DRB Project Number: 2023-008786  
13309 Pino Ridge

SUBJECT: Sketch

**REQUEST:** REZONE / MODIFY BUILDING ENVELOPE(12,000 SQ FT) WITHIN LAND PLOT FOR COMPLIANCE

**Project Name:** 13309 Pino Ridge – Building footprint adjustment

ENVELOPE EXHIBIT

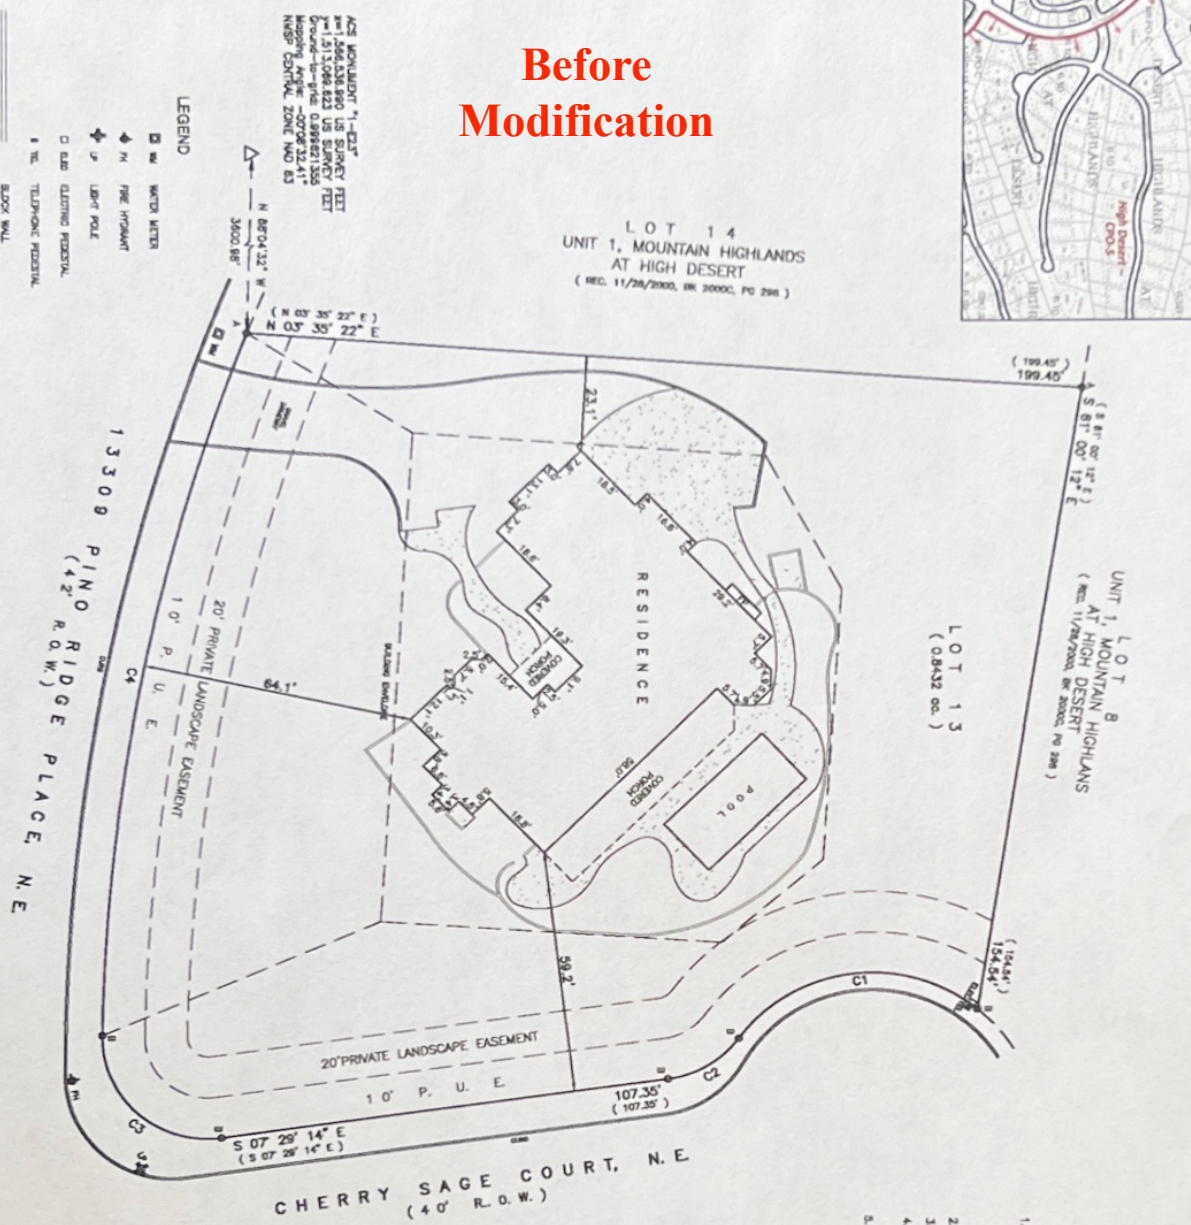
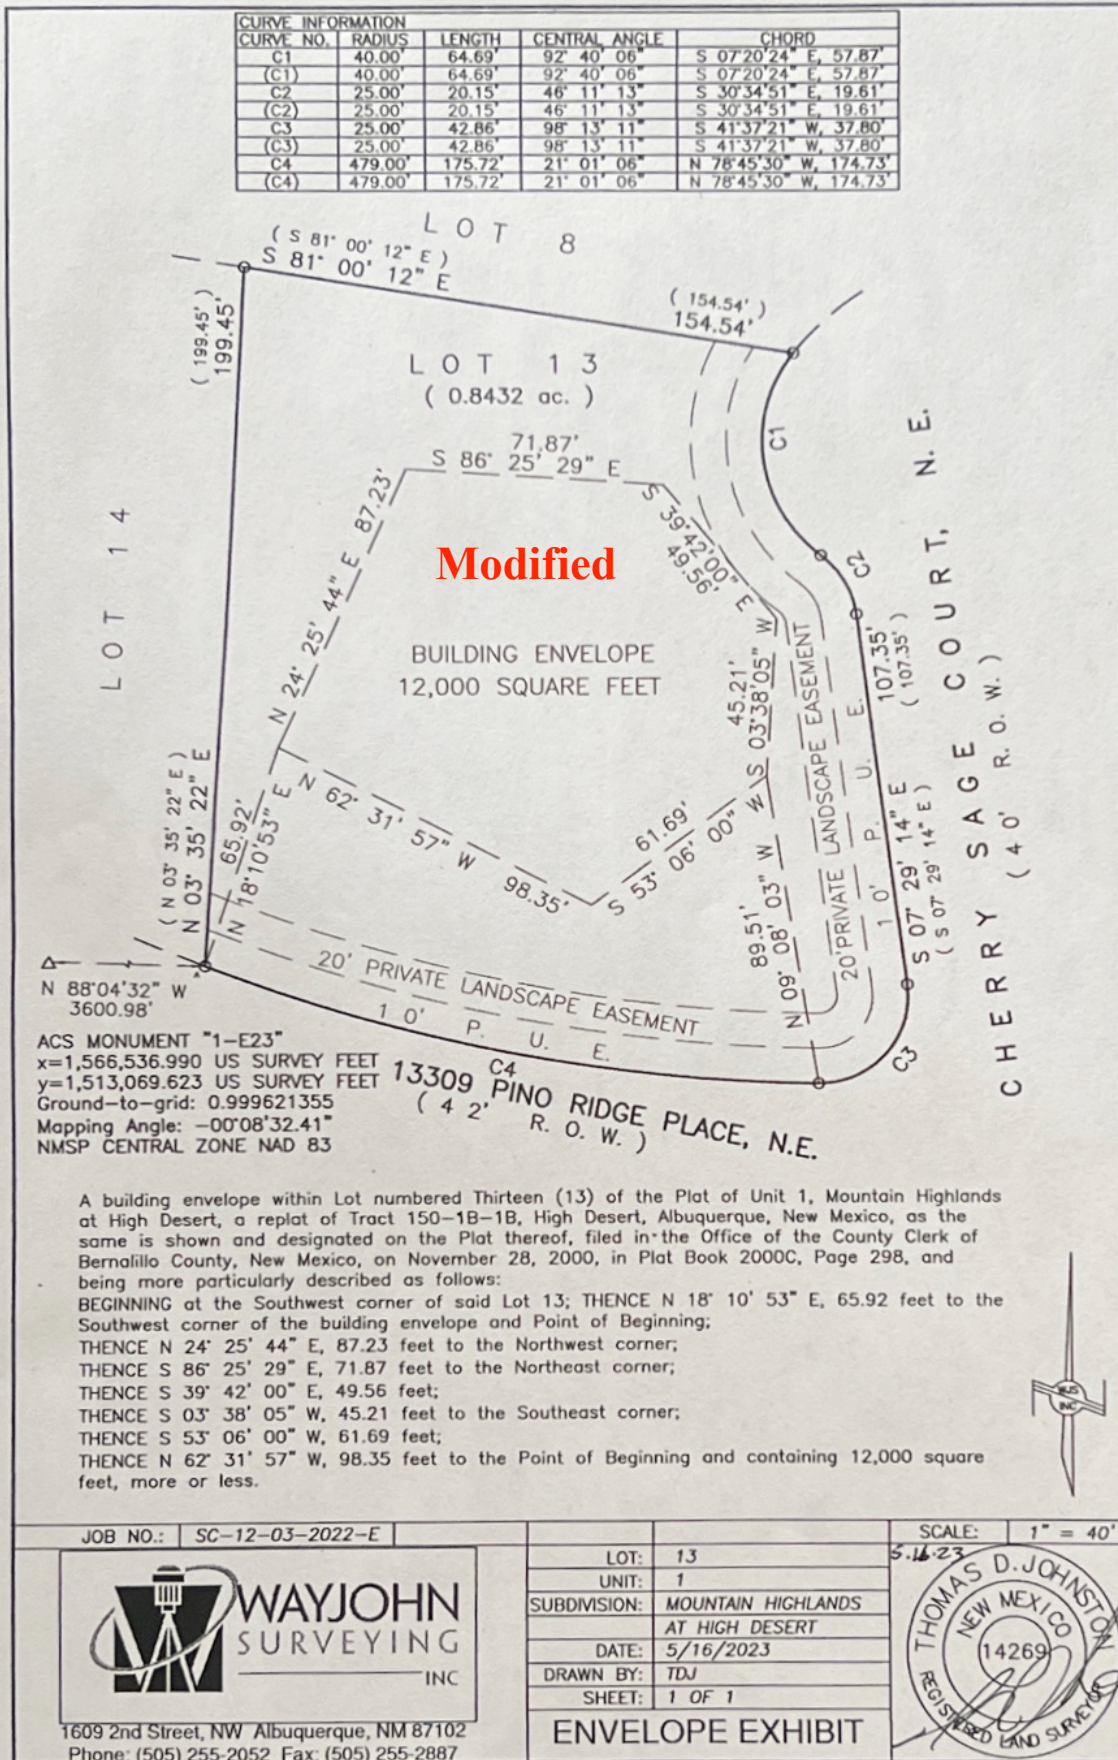
- The building envelope was created by the Plat. If not already completed, it will need to be surveyed and shown on a new plat.  
Existing property lines are not being affected or adjusted.
